Rezoning Petition Review

Date of Review: May 20, 2020 (**Revised June 19, 2020**)

Rezoning Petition #: 20-57

Location of Property: Approximately 92 acres located west of I-485, on the north side of Old Dowd Rd and east of Sam Wilson Rd.

Schematic Site Plan Rezoning Petition #2020-057

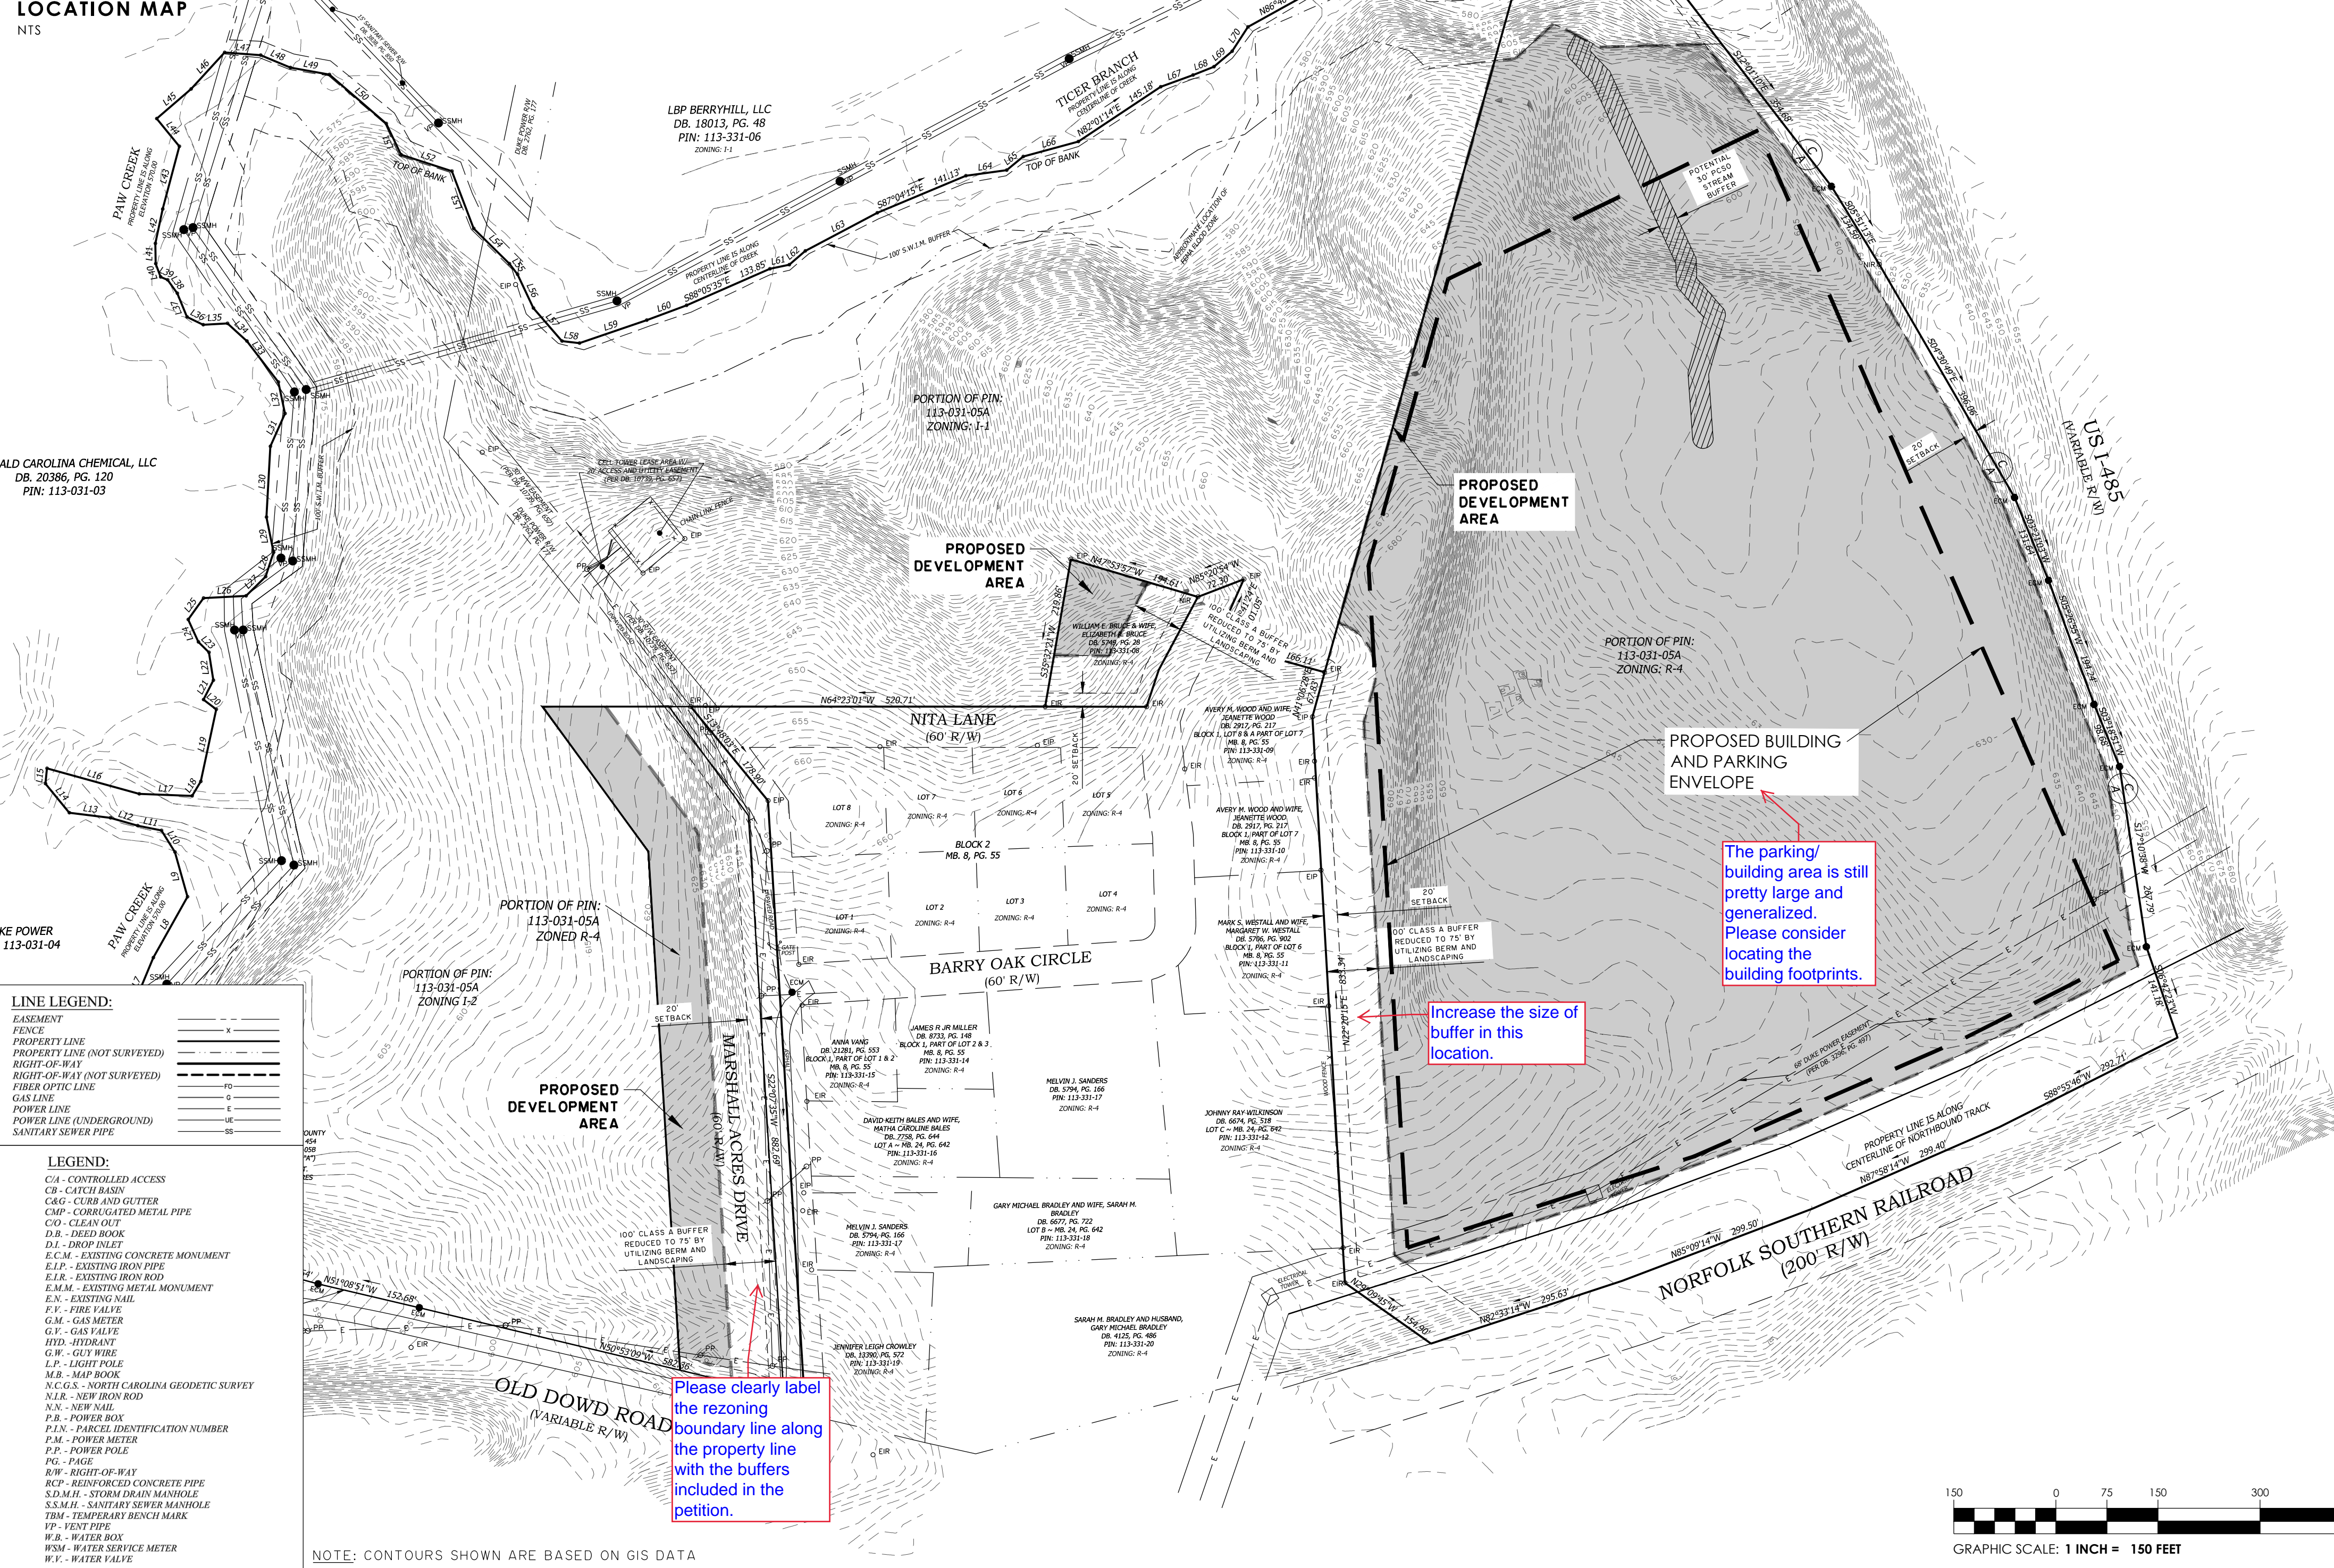
Concerning Storm Water: The rezoning plan sheet indicates a 100-ft SWIM Buffer on site. Please revise buffer label to read “100-ft SWIM/Watershed/PCSO Buffer.”

Petitioner is advised the 100' SWIM/PCSO Stream Buffers on the site may require additional flood fringe area as additional stream buffer. Delineation of the additional stream buffer area may be deferred to the permitting process and is not required to be shown on the rezoning plan.

City GIS indicates a 30-PCSO buffer on the eastern portion of the proposed development and parallel to I-485. Please include the following note under *Environmental Features: Development within the SWIM/PCSO Buffer shall be coordinated with and subject to approval by Charlotte-Mecklenburg Storm Water Services and mitigated if required by City ordinance. Stream Delineation Reports are subject to review and approval by Charlotte Storm Water Services.*

Due to revisions (6/19/20): The rezoning plan sheet indicates a 100-ft SWIM Buffer on site. Please revise buffer label to read “100-ft SWIM/Watershed/PCSO Buffer.”

Please include the following note under *Environmental Features*:
Development within the SWIM/PCSO Buffer shall be coordinated with and subject to approval by Charlotte-Mecklenburg Storm Water Services and mitigated if required by City ordinance. Stream Delineation Reports are subject to review and approval by Charlotte Storm Water Services.
